**RE: BP#2017-00387 8 Middle Street - Further plan review comments**

*Provide detail showing fire partition between dwelling units per Section 709.*

3 TILSON ADA GUEST ROOM ENLARGED PLAN
1/4" = 1'-0"

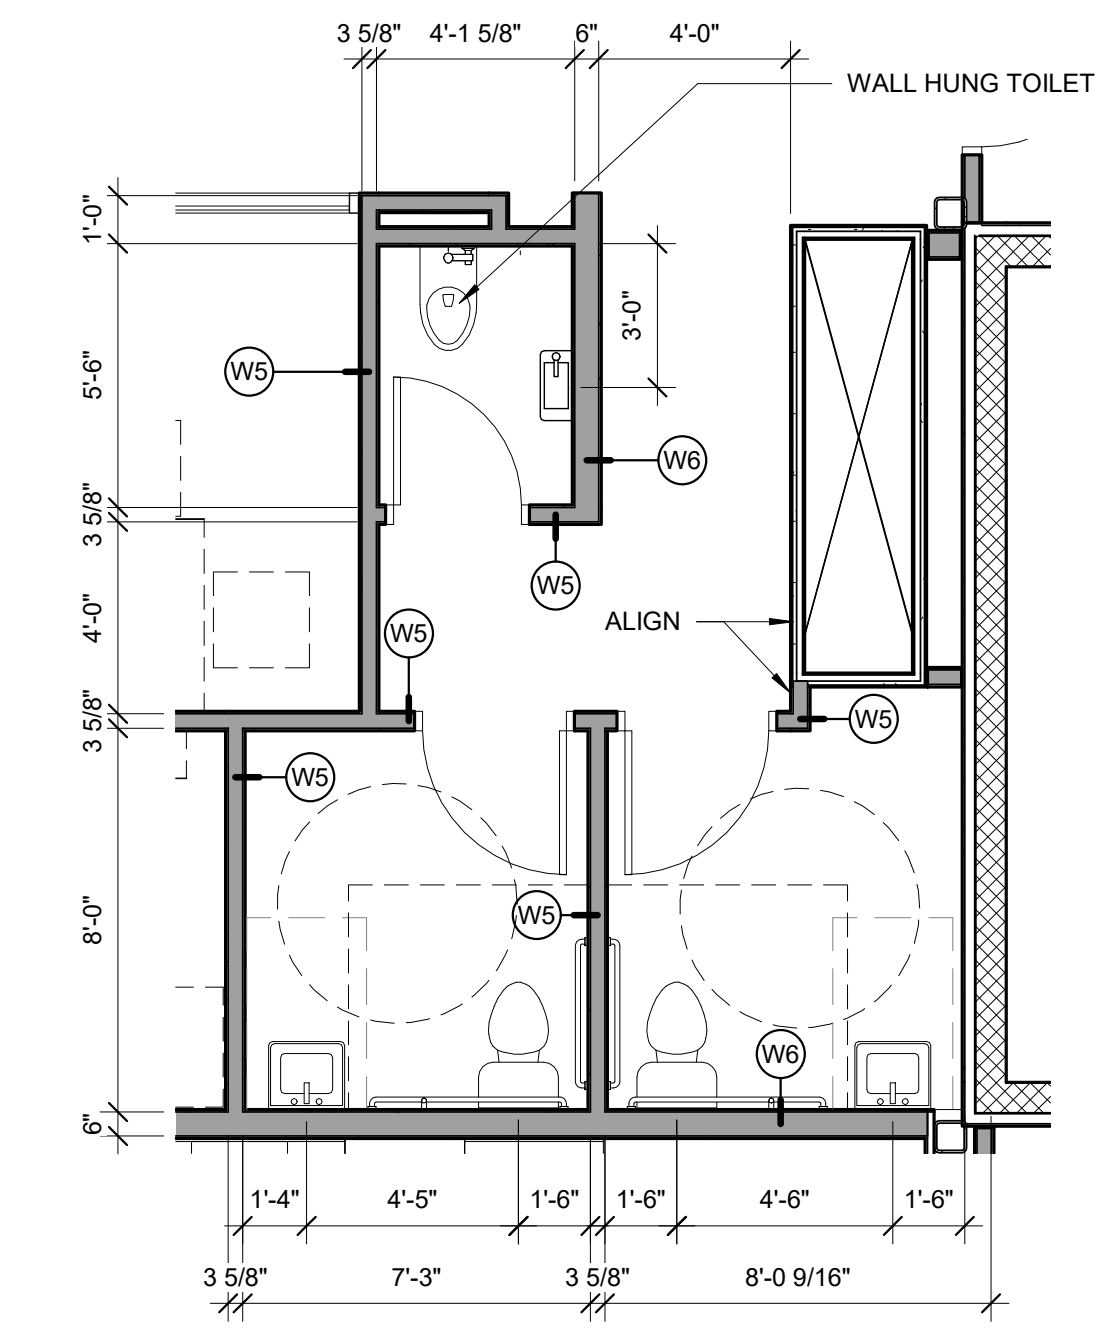
*Verify maneuvering clearances per the 2010 ADA.*

See sheets A1.13 and A1.14 for enlarged bathroom plans. All fixture clearances and turning radiuses are accounted for. Also on sheet A1.14 we have our typical ADA elevations showing required clearances/dimensions.

6 ADA POCKET DOOR
1" = 1'-0"

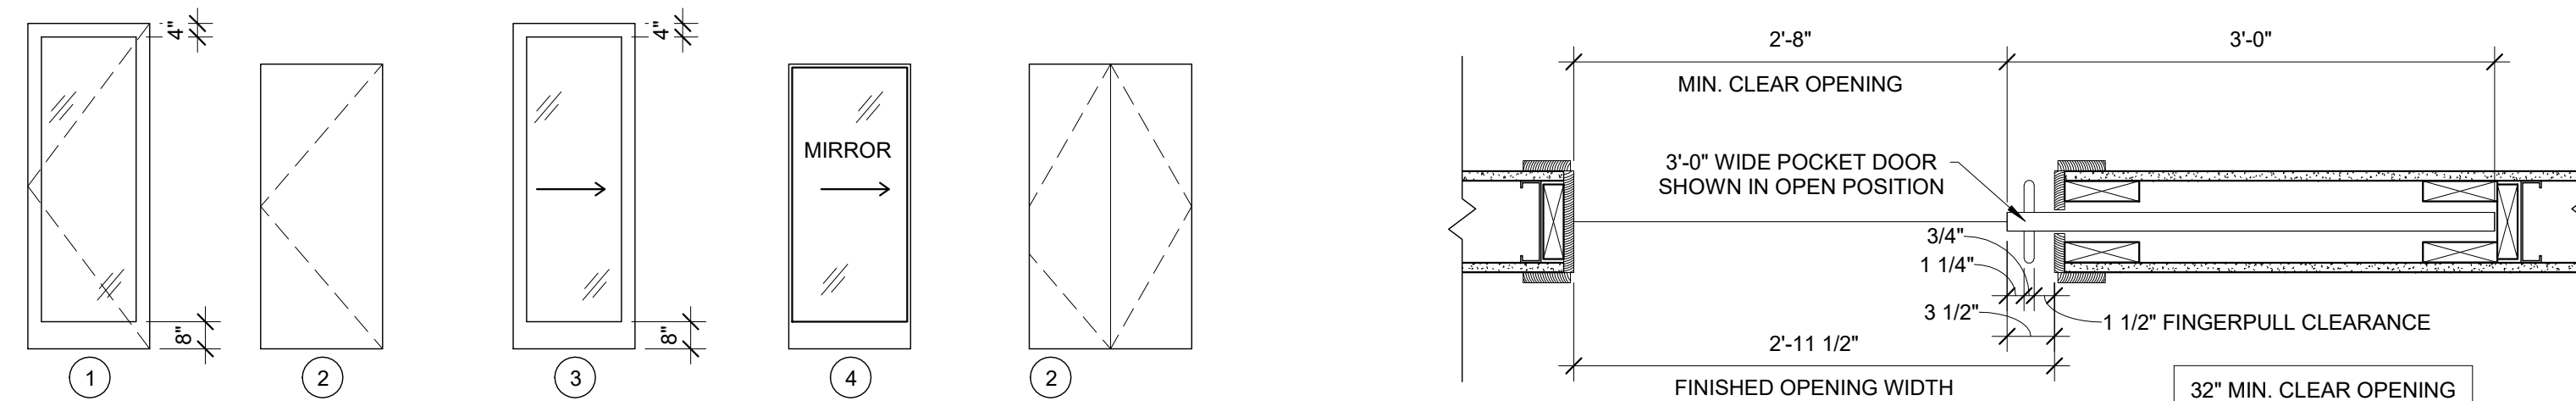
*Verify maneuvering clearances per the 2010 ADA for pocket door in ADA Guest Unit.*

See sheets A1.15 for the ADA Pocket Door detail showing our dimensions to meet ADA and ANSI.
